**City of Albuquerque**  
**Parks and Recreation Department**  
PO Box 1293, Albuquerque, New Mexico 87103  
Inter-Office Correspondence

Development Review Board Comments

**Project Number:** 1002342  
**Application Number:** 03DRB-02178

**RE: Petroglyph Gardens/final plat**

PRELIMINARY PLAT FOR  
**PETROGLYPH GARDENS  
 SUBDIVISION**

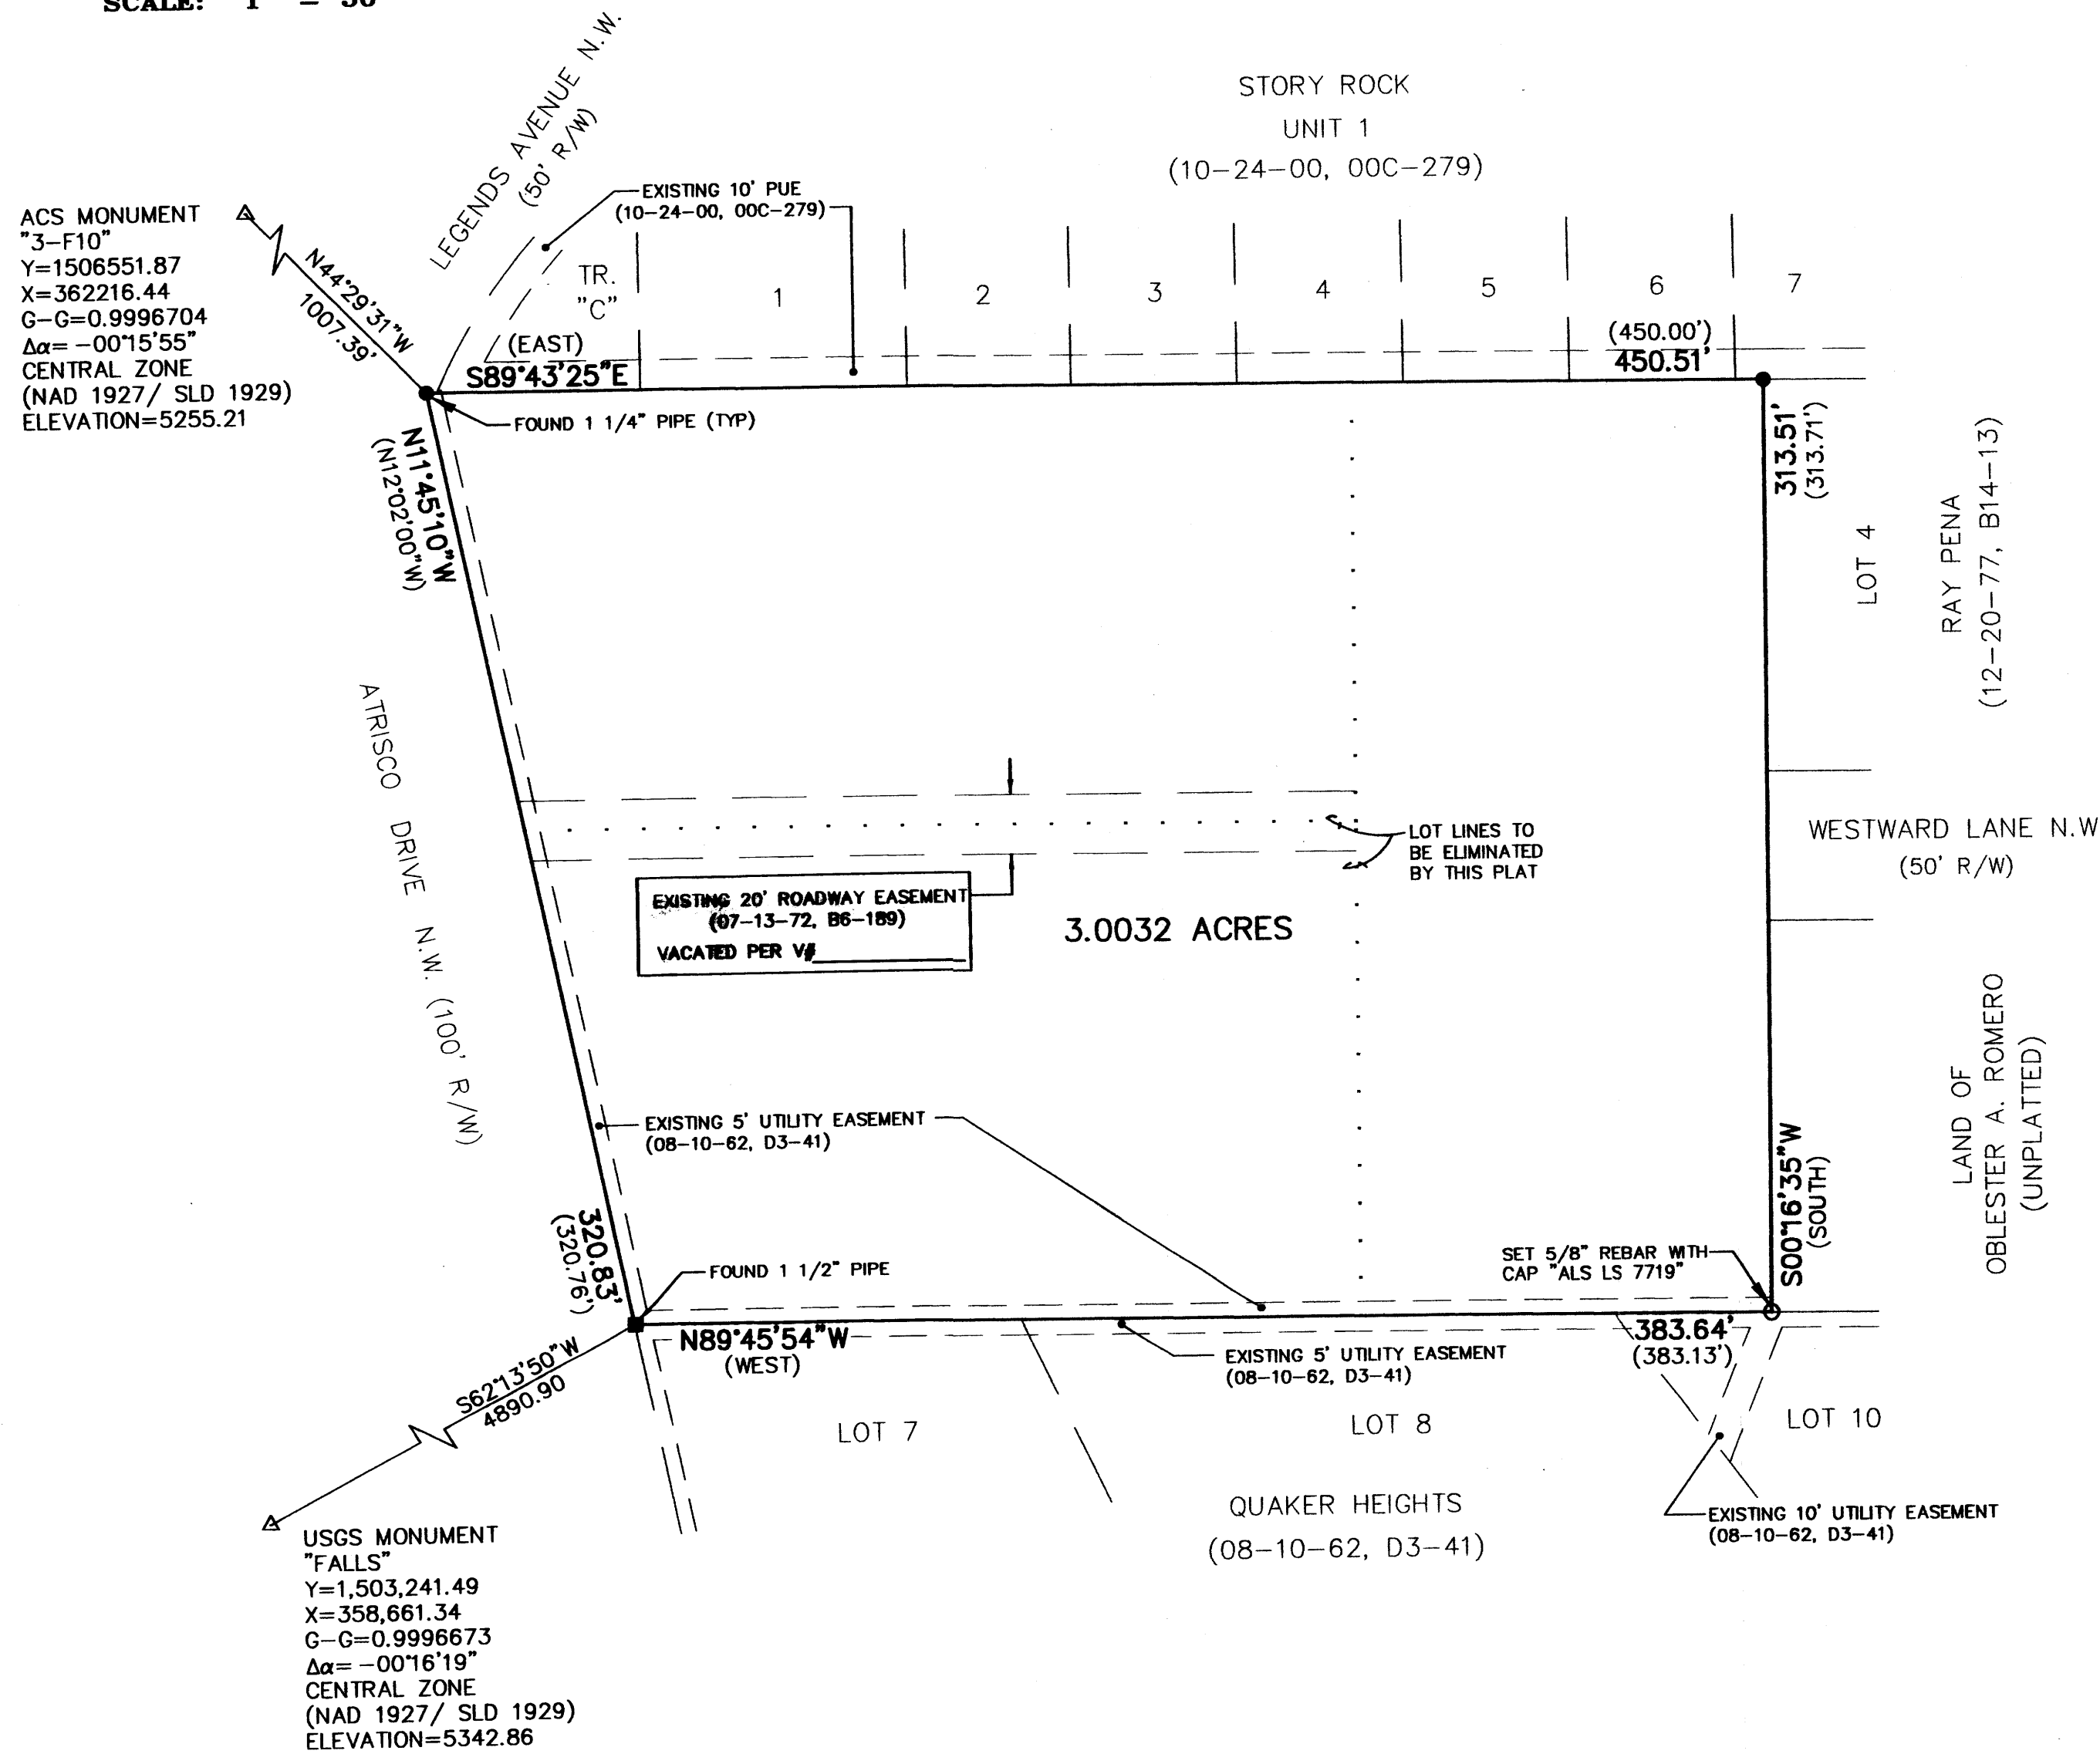
Scale is wrong on sheet 3.
